This project is a request for a mini-warehouse as a Special Use in the CC zoning district.

Date: March 19, 2024

RE: MyGarage @ Northcrest – 2510 Canada Dr.
Site Development Plan Amendment, Special Use

DRAWING NO.  
1  
SPECIAL USE PLAN

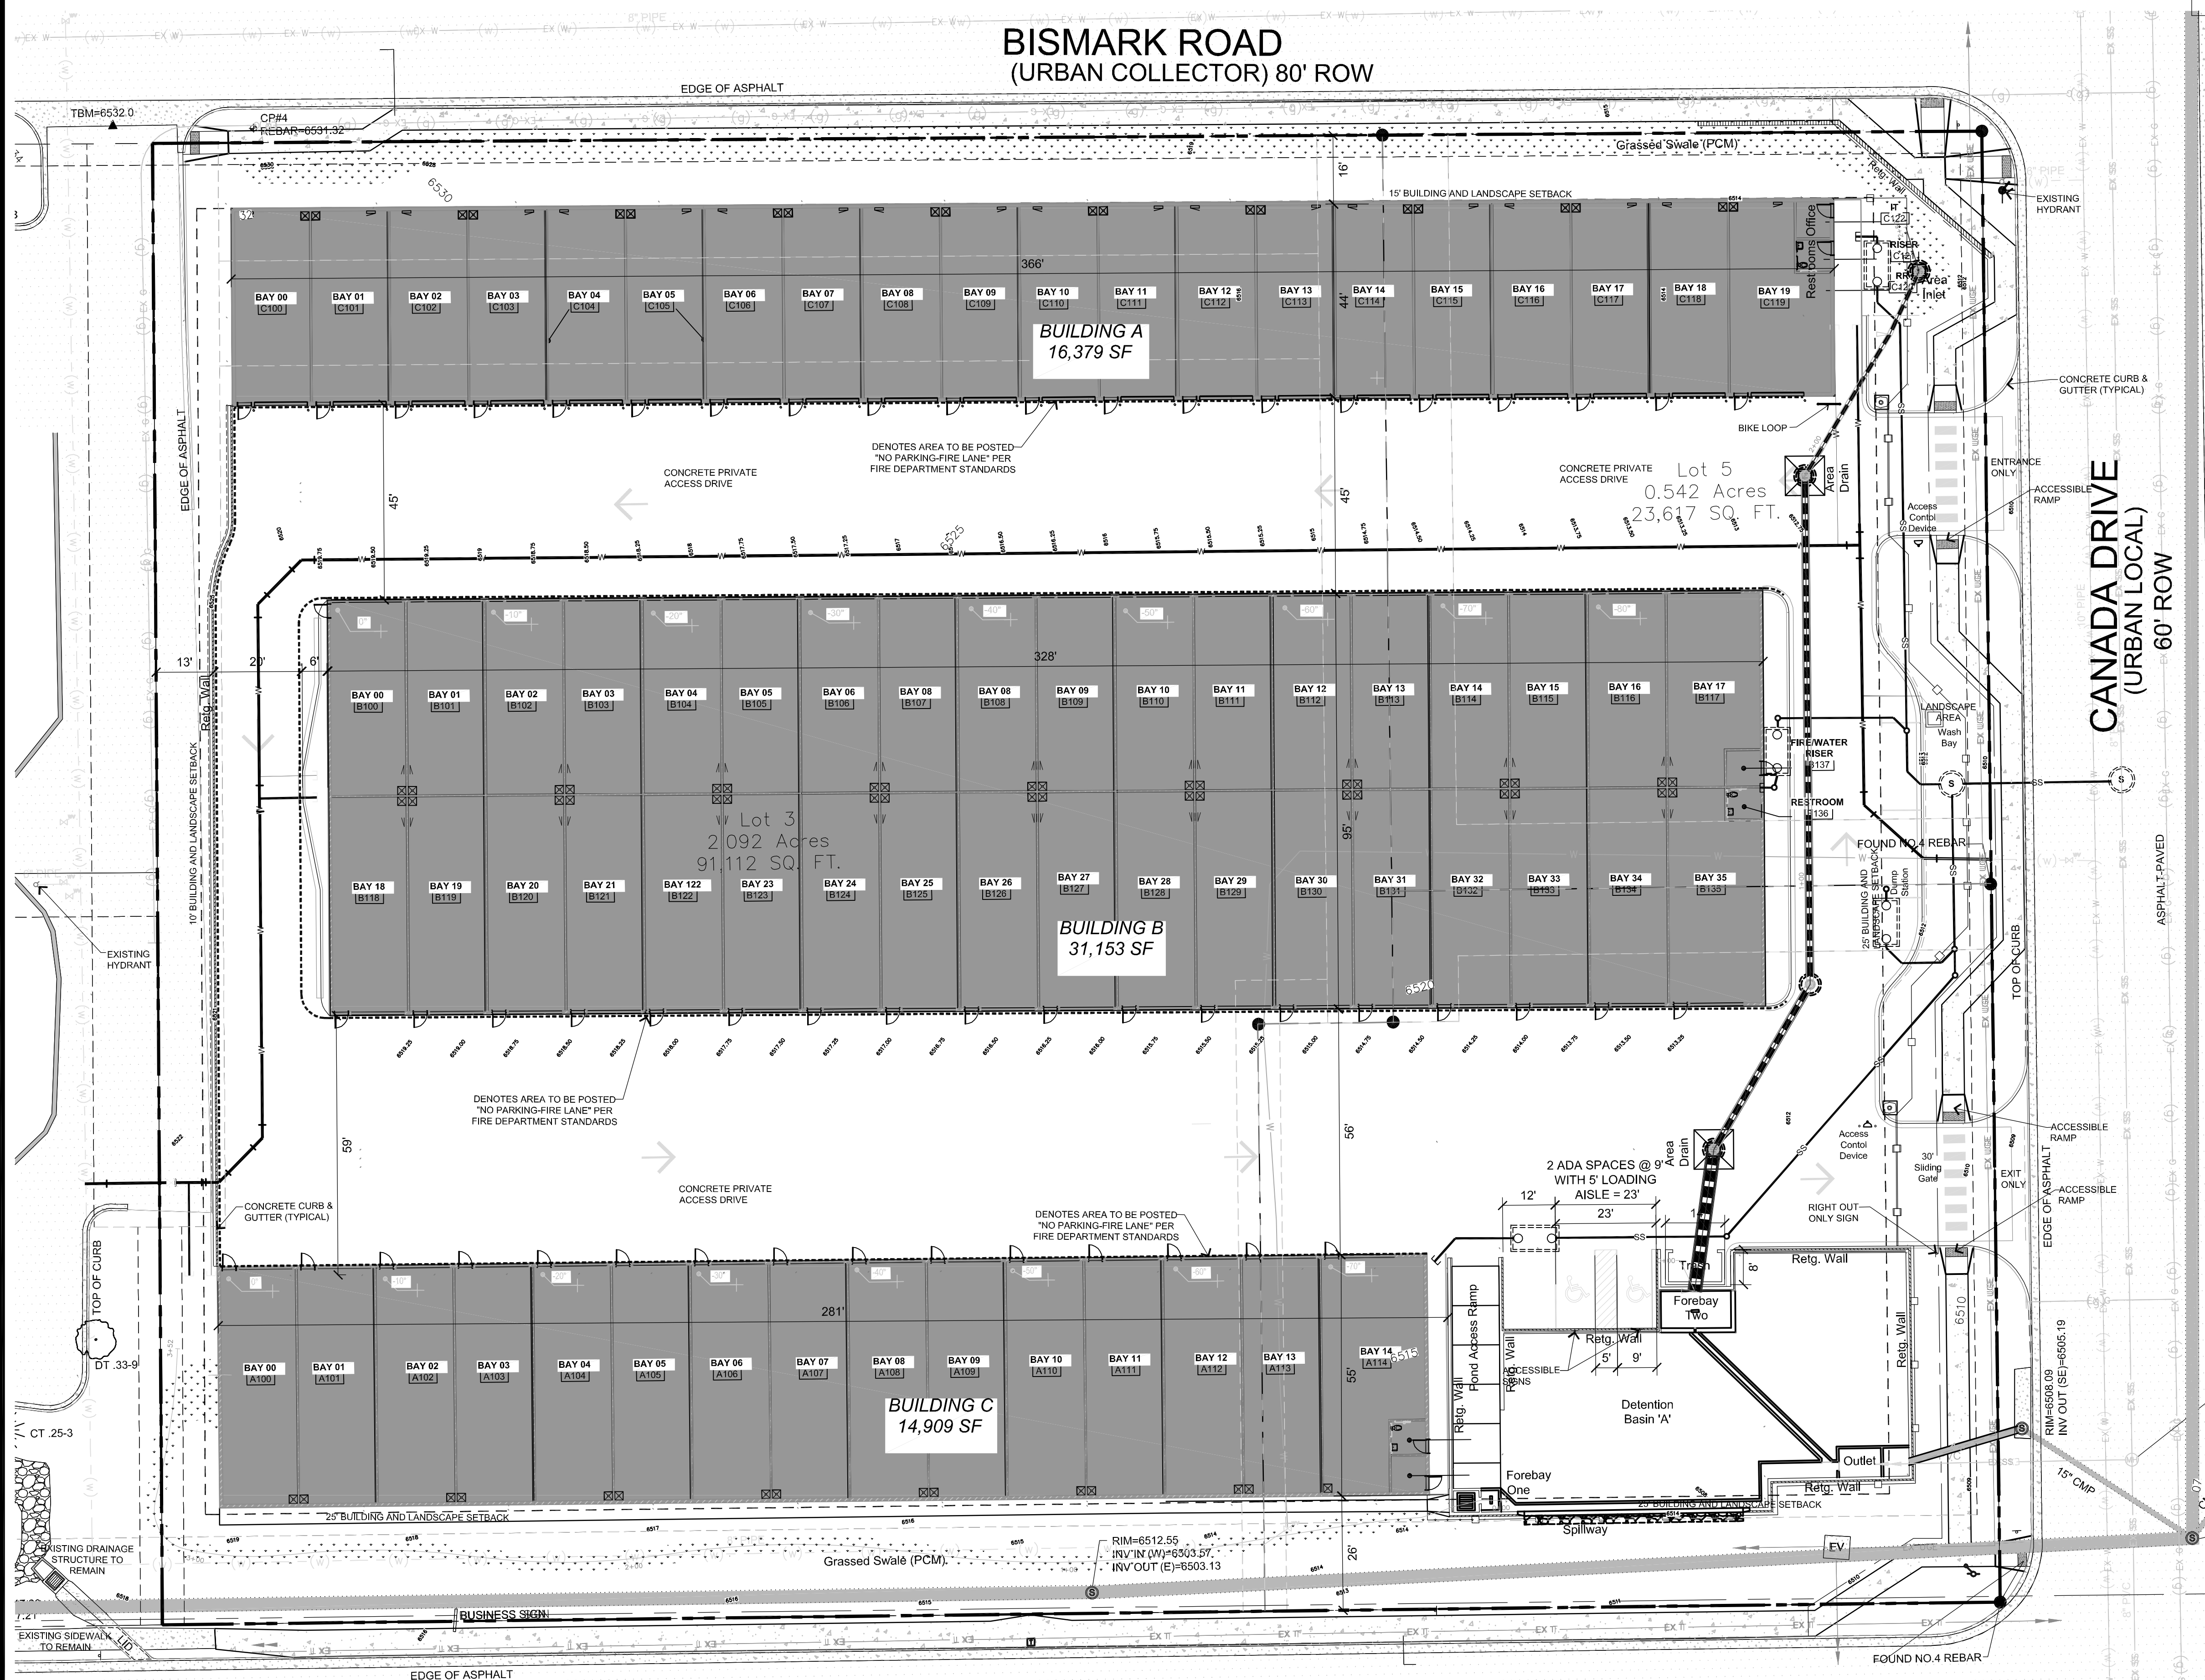
Please discuss how the setbacks are being met e.i where will the structures be located.

Explain controlled access or lack thereof. SDP shows no controlled access with gates typical of a self storage type business. Also units have water and power in them and common area bathrooms.
